Development Facilitation Team (DFT) – Review Comments

Project No: PR-2023-008891 Date: 08/09/2023 Agenda Item: 5 Zone Atlas Page: K-14

Location: 701 CENTRAL AVE NW between 7th st and 8th st NW

CARTESIAN SURVEYS, INC. agent for **701 CENTRAL LLC** requests the aforementioned action(s) for all or a portion of: **LOTS 13 THRU 16, BLOCK 14, NM TOWN CO.'S ORIGINAL TOWNSITE** zoned **MX-FB-UD**, located at **701 CENTRAL AVE NW between 7TH ST NW and 8TH ST NW** containing approximately 0.3261 acre(s). (K-14)

**Plat for  
 Lot 13-A, Block 14, New Mexico  
 Town Company's Original Townsite  
 Being Comprised of  
 Lots 13 thru 16, Block 14, New Mexico  
 Town Company's Original Townsite  
 City of Albuquerque, Bernalillo County, New Mexico  
 July 2023**

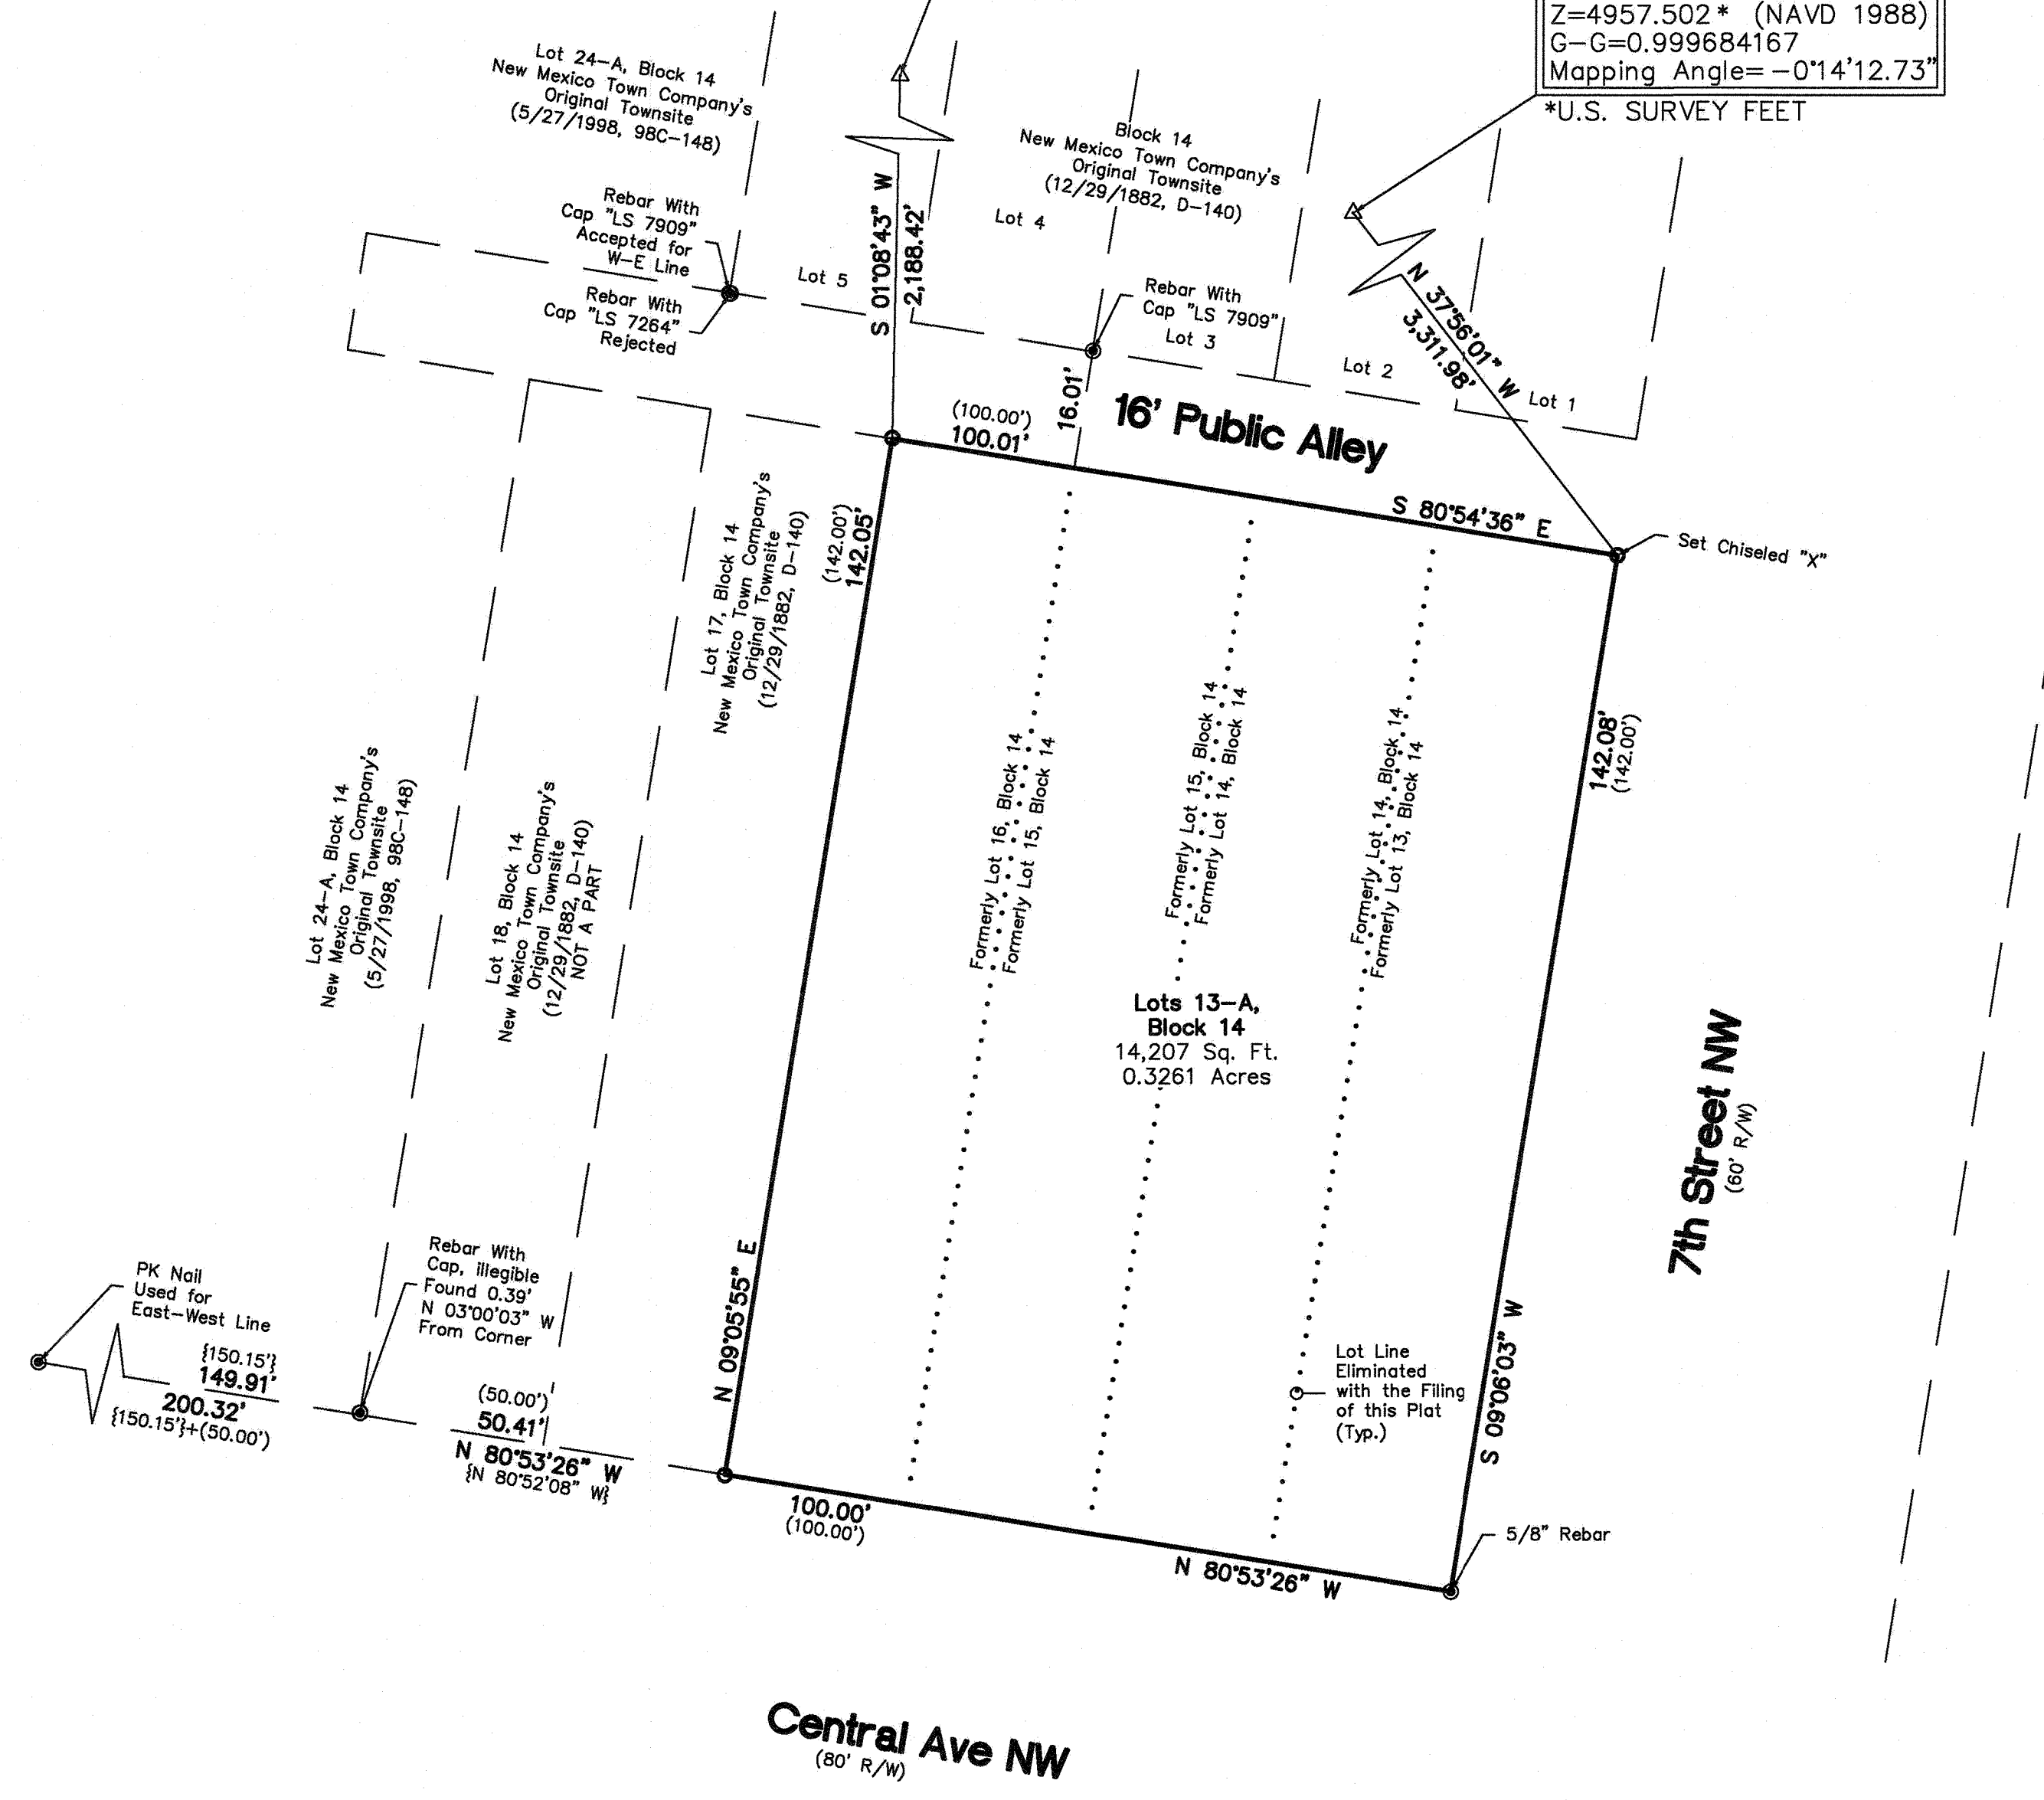
- The application number must be added to the Plat prior to final sign-off by DFT staff, should the Plat be approved by the DHO.
- The Plat included a DPM note regarding a DHO determination. The applicant included a justification letter within the submittal and justified the request per the IDO criteria.
*Please be prepared to discuss the justification letter details at the upcoming hearing.

- ***Please confirm ROW development and any changes. Include compliance detail for section 7 of the DPM Table 7.2.29 regarding Sidewalk width requirements and its landscape buffer.**

- *Verification of standards per Transportation***
 - Location is within a Center/Corridor area. This is also a Bike Route area.
 - 7th St is a local street within a Center/Corridor. Requires a 10 ft-12 ft sidewalk and 6 ft-8 ft landscape buffer

- Central Ave is a Main Street, Premium Transit/Major Transit, Minor Arterial within a Center/Corridor. Requires a 10 ft-12 ft sidewalk and 6 ft-8 ft landscape buffer.
